An Bord Pleanála Oral Hearing

Case reference: PL06F.301908

Submission by

Sabrina Joyce-Kemper

TITLE: Exploratory hole location plan

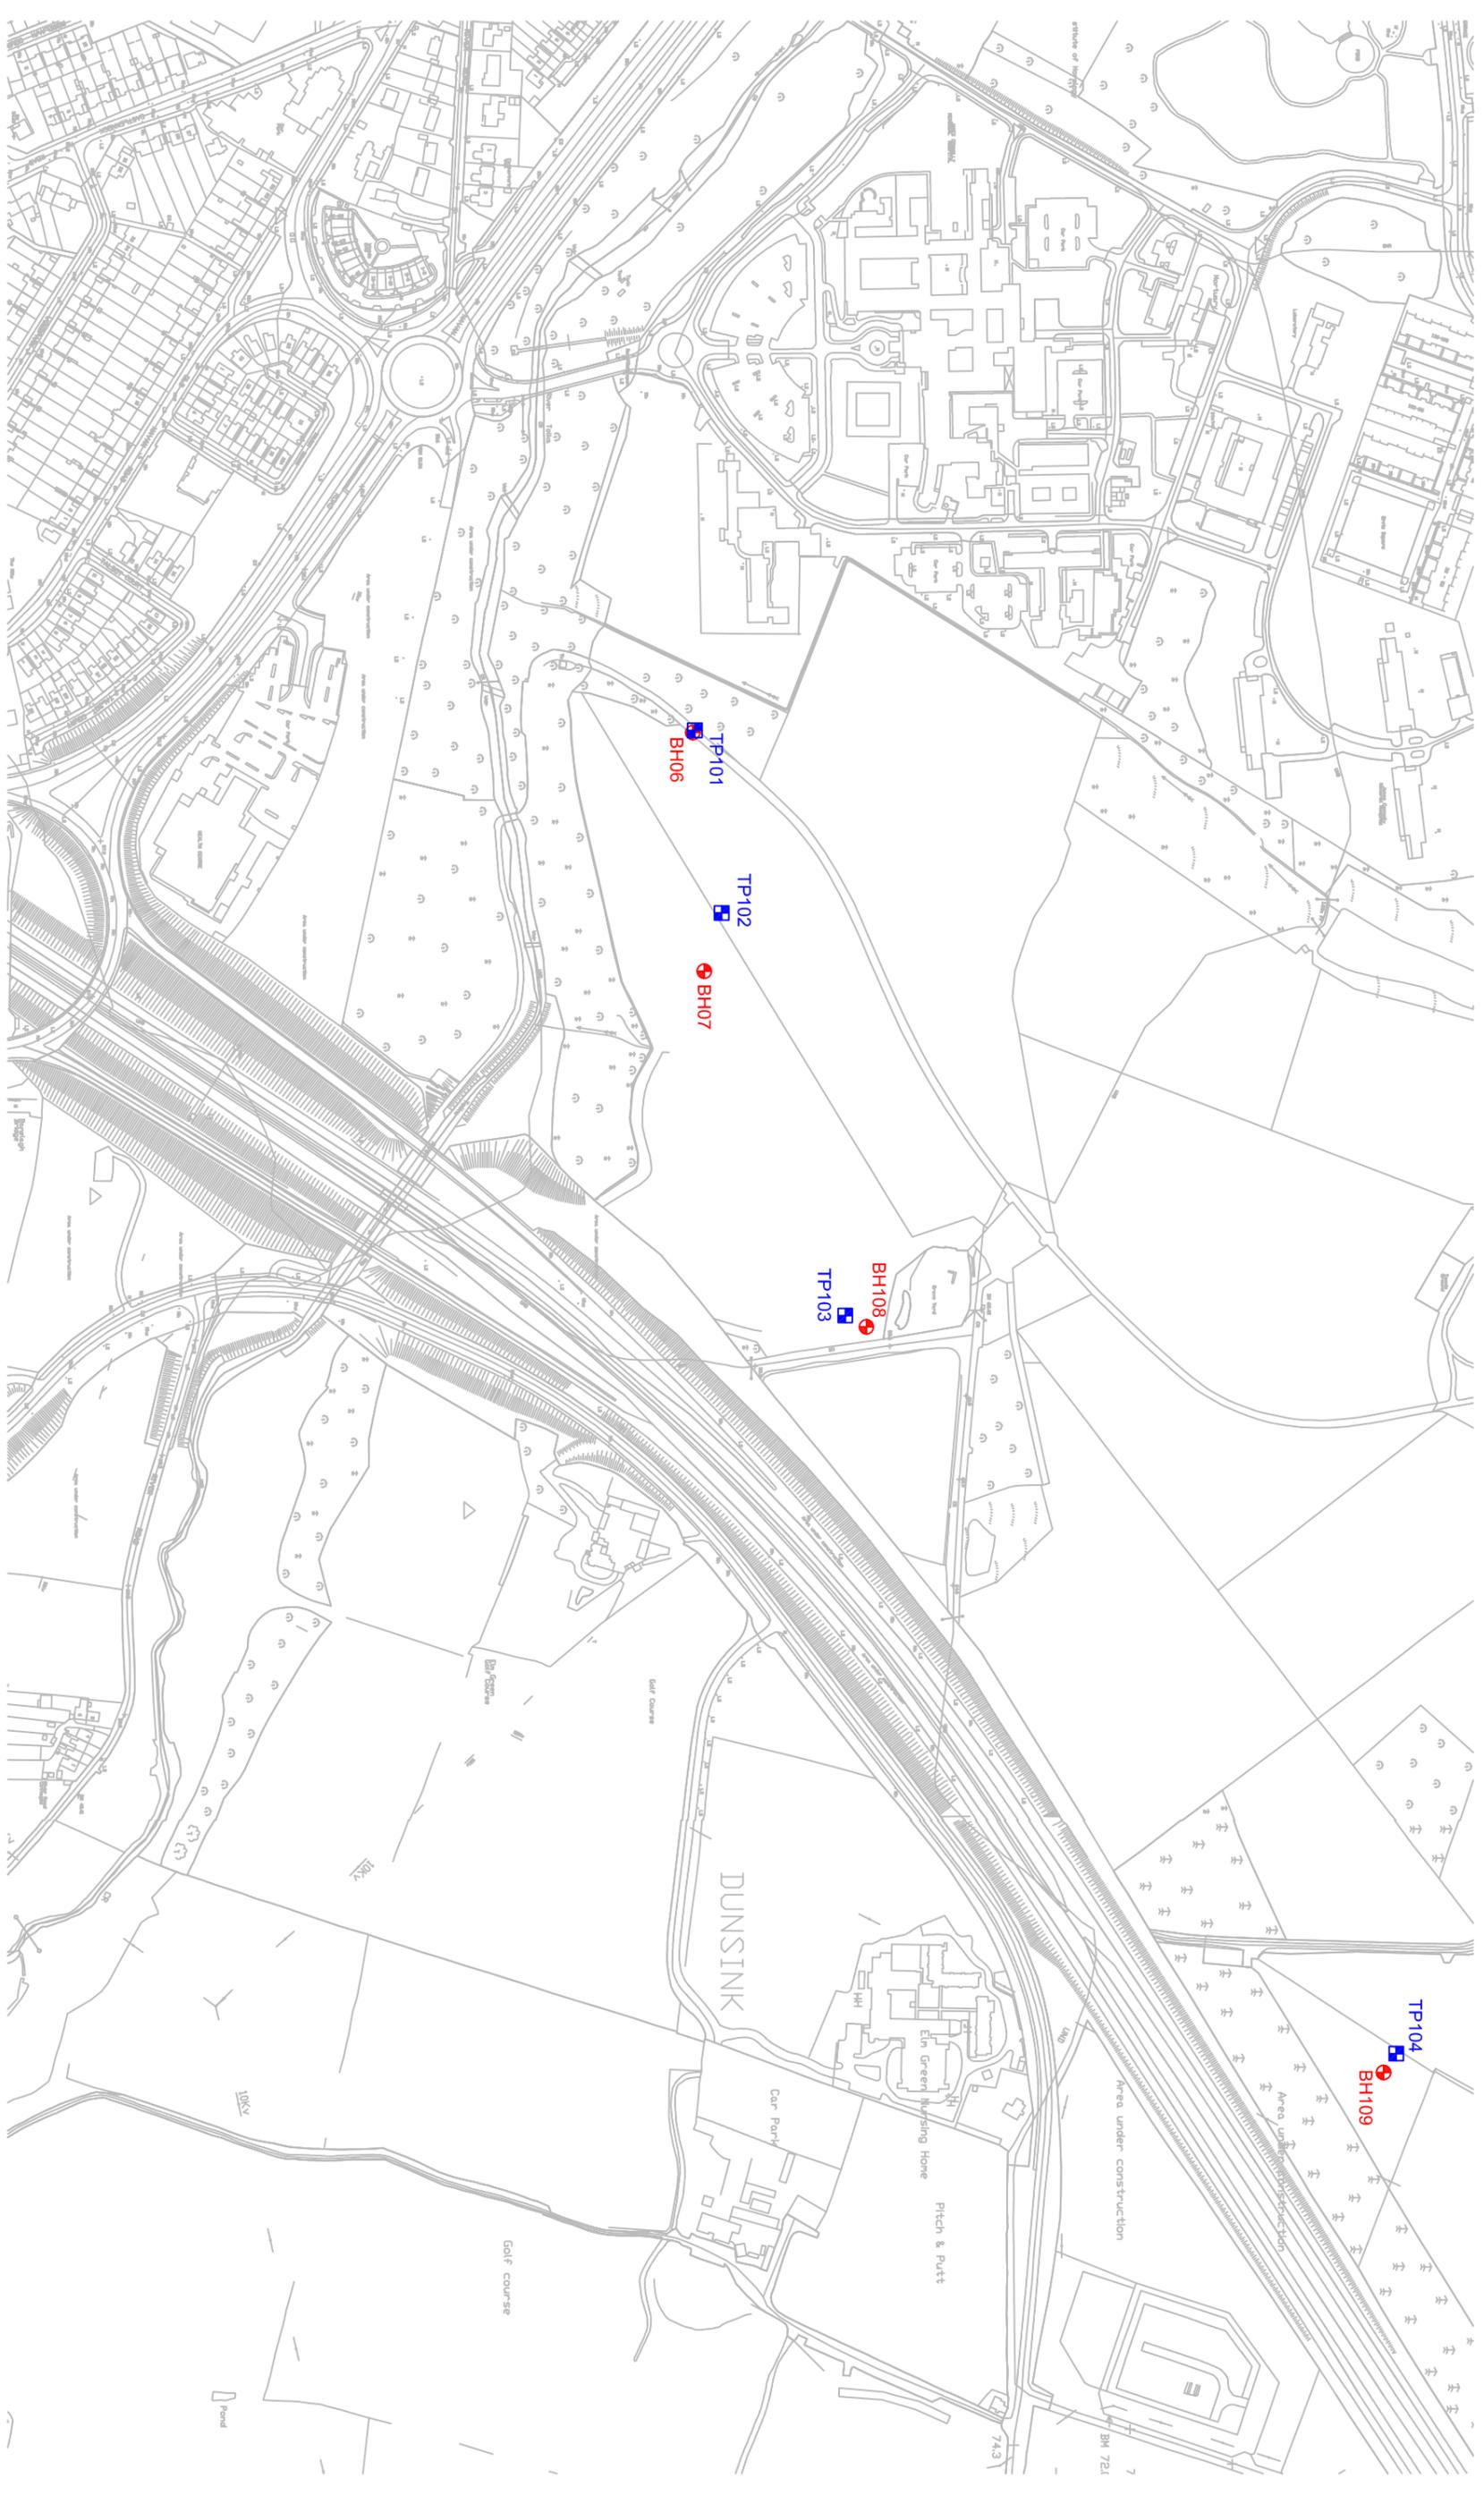
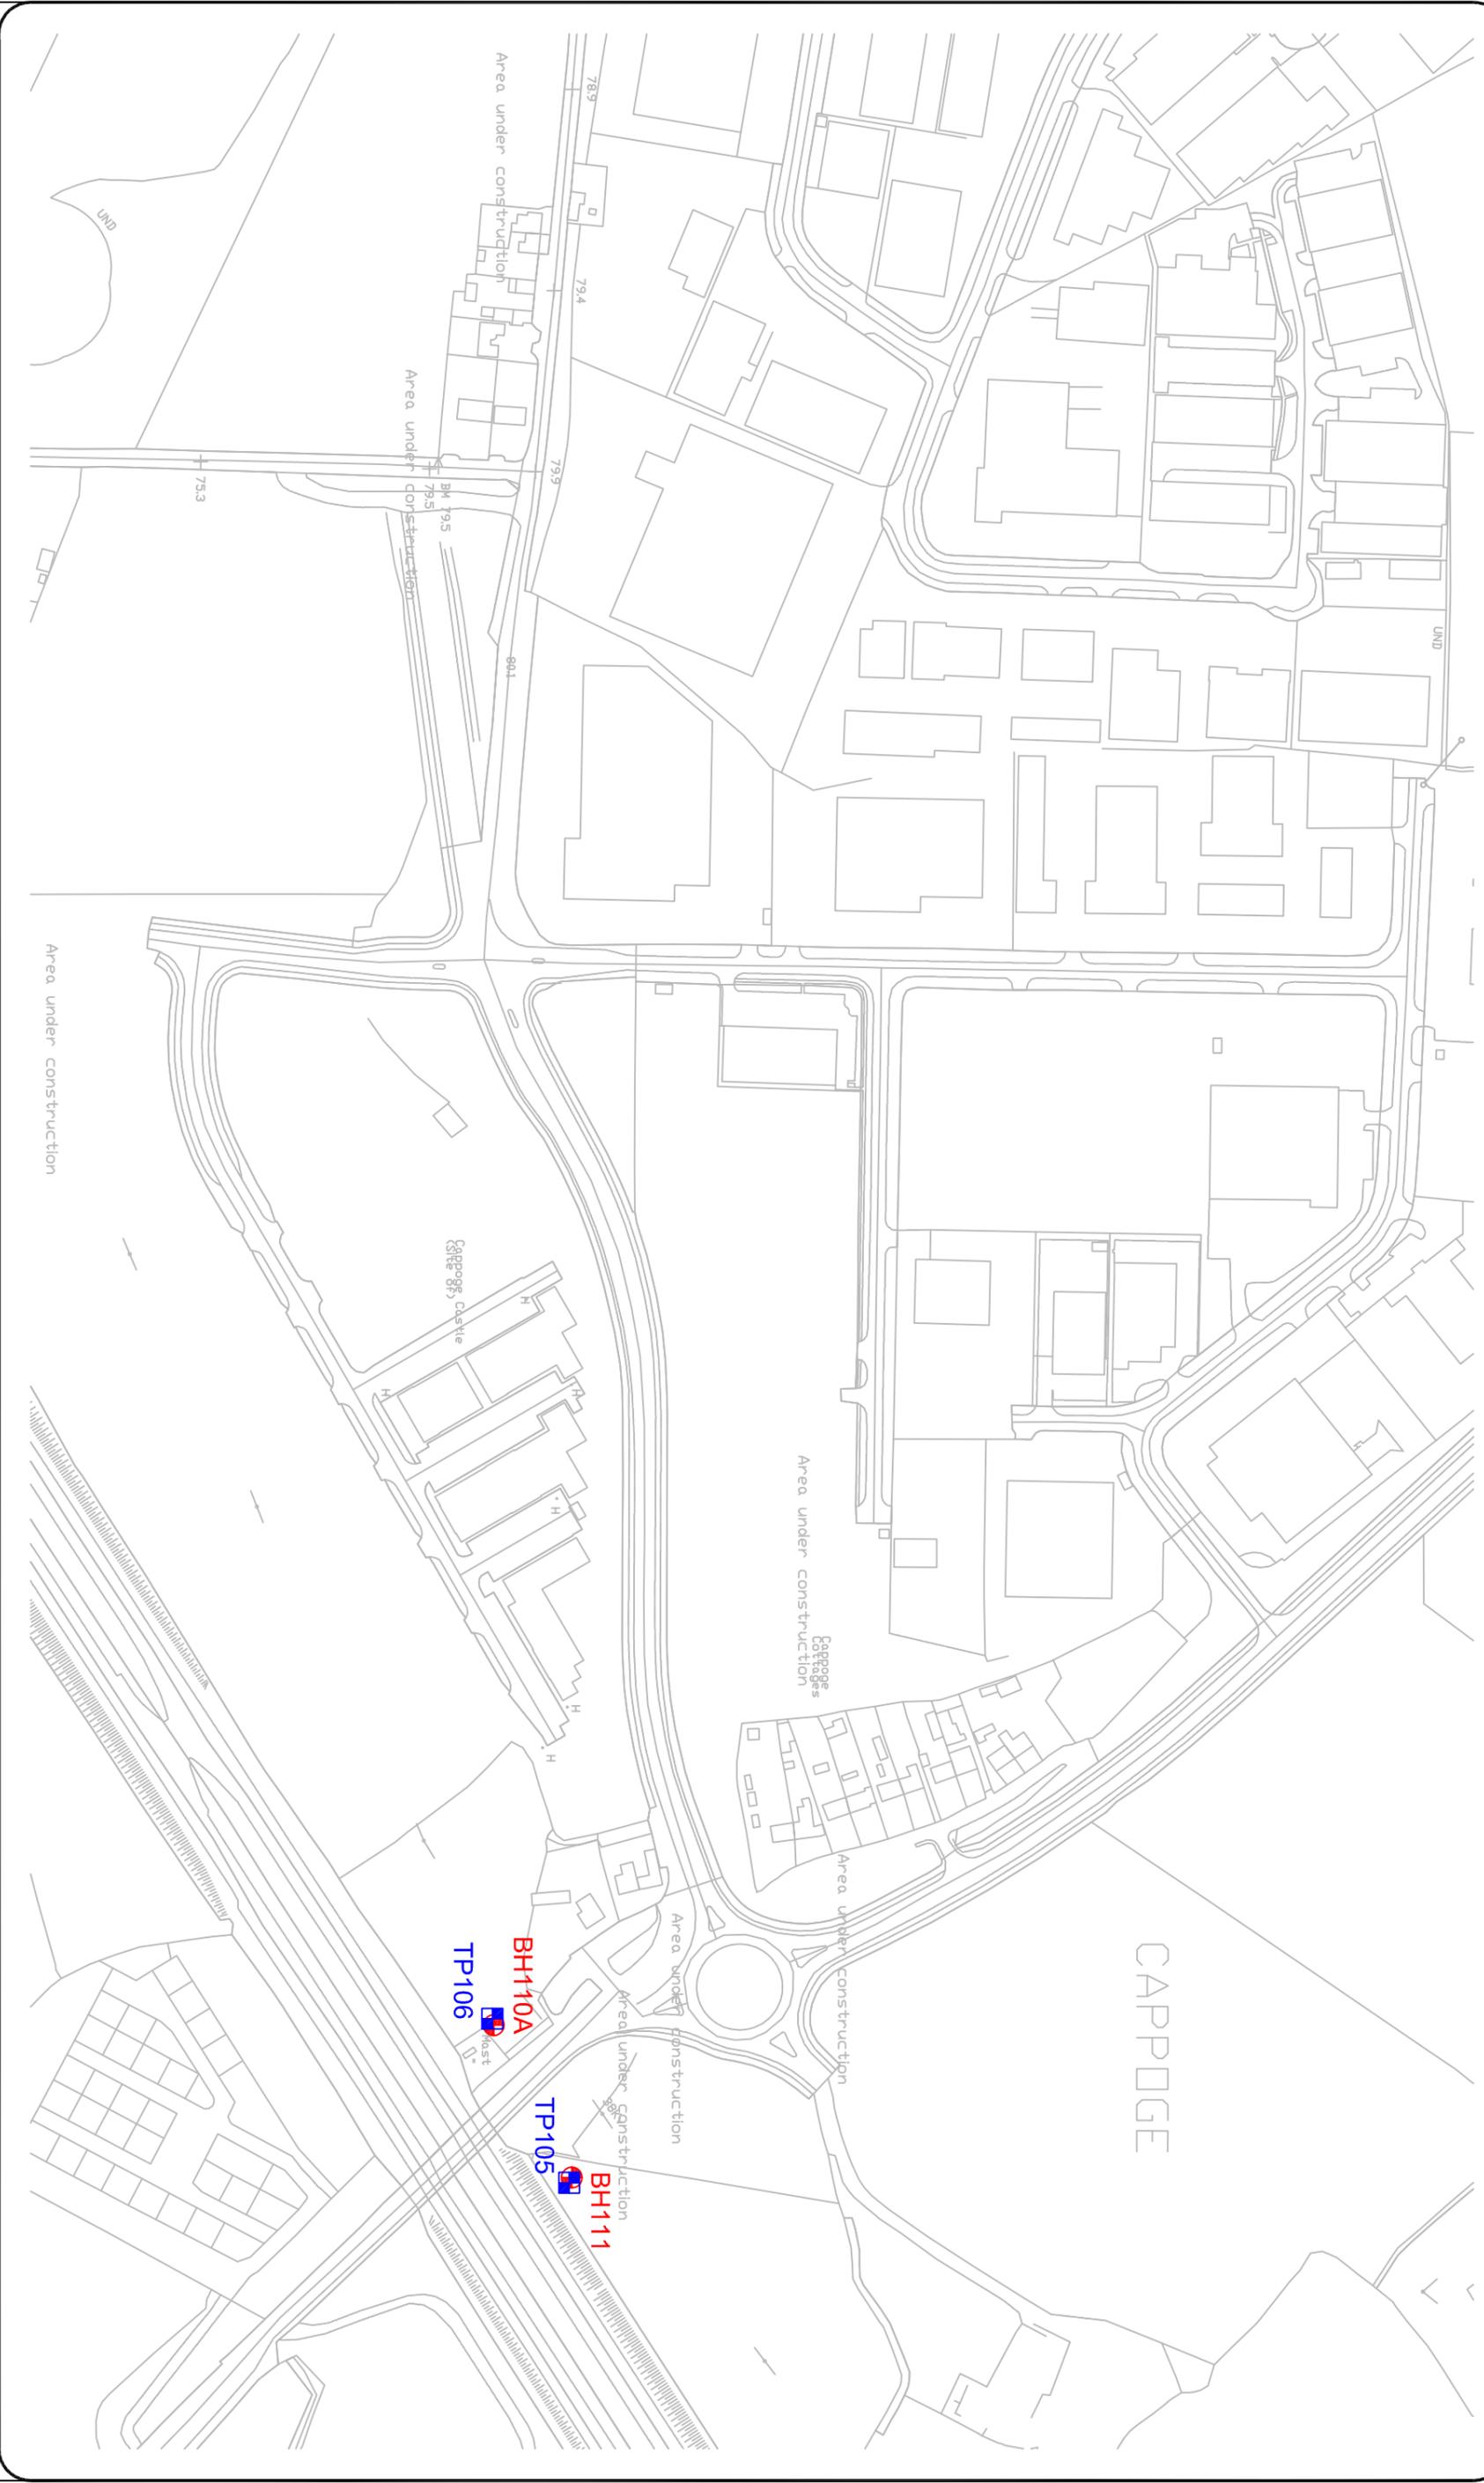
26. Irish water does not have actual scientific information regarding the geology directly under Baldoyle Estuary where the Tunnel boring will actually take place. Borehole samples were taken each side of the estuary on dry land but none were taken within the estuary itself due to its strict protected status. The NIS states the following: *"The risk of a surface breakout by bentonite drilling fluid cannot be negated completely due to variability in the underlying geology. A detailed geophysical survey has been carried out along the proposed route in order to anticipate the risk of weak formations and possible faults that may increase the risk of a bentonite breakout. However, should the TBM encounter voids within the formation (such as a fissure or weathered area of rock), and then material can be forced to the surface under pressure to create a breakout. In the littoral and sub-littoral environments, the presence of bentonite at the surface can have a notable impact on sediment turbidity and suspended load. This increase in turbidity could result in increased siltation and the smothering of sediments and organisms accompanied by a reduction in the light available to the seabed for photosynthesis."*
